# City of Albuquerque Stormwater Construction Site Inspection Report

ESC File No.	D18E009A	Project Name:	Hope Christian Elementary School		
NPDES Id. No.	NMR1002NC	Location:	6801 Palomas		
4/13/2021	Owner	Contractor			
Operator	Hope Christian School	PWKI			
Contact name & title	Ieresa Groom	Adam Kenderdine			
e-mail	<a href="mailto:tkgroom@hcsnm.org">tkgroom@hcsnm.org</a>	<a href="mailto:adam@pwki.com">adam@pwki.com</a>			
Contact Phone #	505-821-2513	505-908-5066			
COA Inspector	Thomas Evans	Start/End Time:	12:55 PM/1:30 PM		
Construction Phase:	Landscaping				
Type of Inspection:	Regular	Storm Event	Past Storm Event >0.25"	311/Complaint	Follow Up
Weather at time of inspection?	Clear		Temperature: ~	59	
Estimated date of last storm 0.25" or greater	2/22/2021

1 EROSION AND SEDIMENT CONTROL -
PROPOSED CONDITIONS
1" = 30'-0"

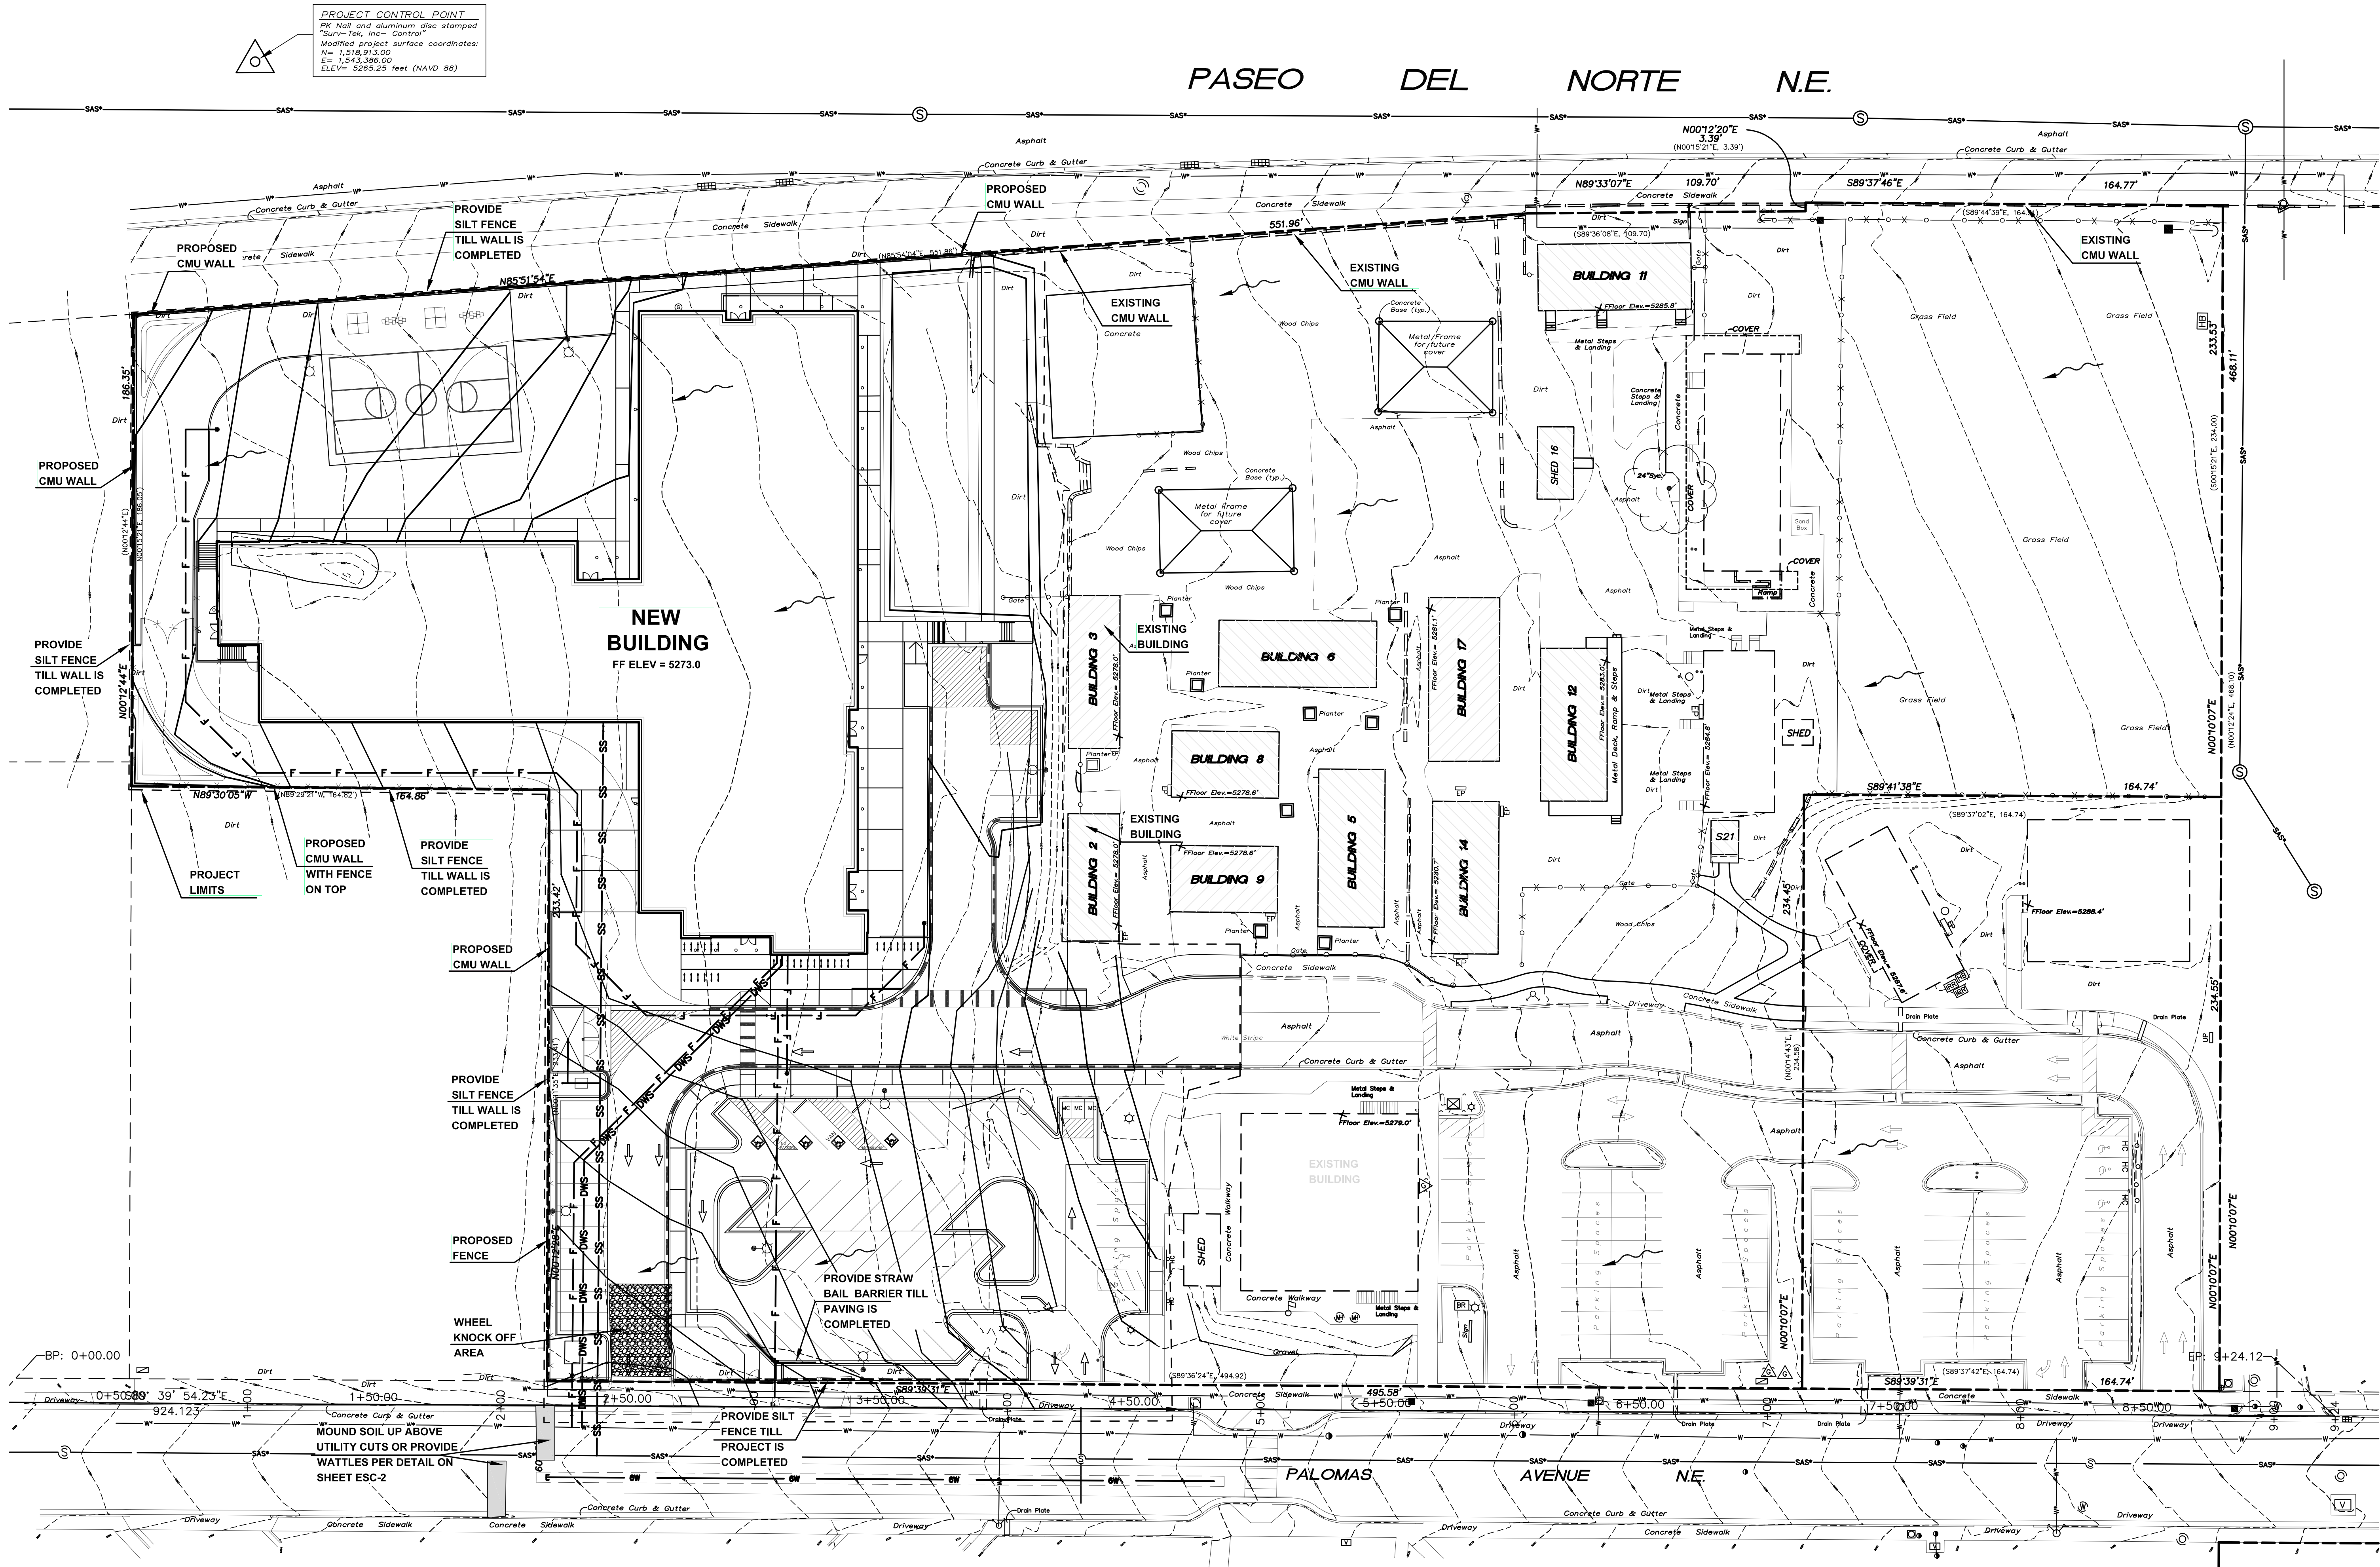
Item Number	Deficiency/ Corrective Action				
1	No BMP installed at entrance to limit trackout				
2	Sweep streets/sidewalks of trackout				
3	BMP's should be placed at pond outlets along West wall of site.				
4					
5

Notes: Spoke with Adam Kenderdine. The inspection reports are filed electronically. He confirmed the date of the last inspection report listed above. The SWPPP is kept onsite. Site is expected to be completed in the next 2-3 weeks. There is a concern that there may be sediment in the downstream channel. There should be BMP's in place at the pond outlets and be better formed to act as temporary sediment traps.
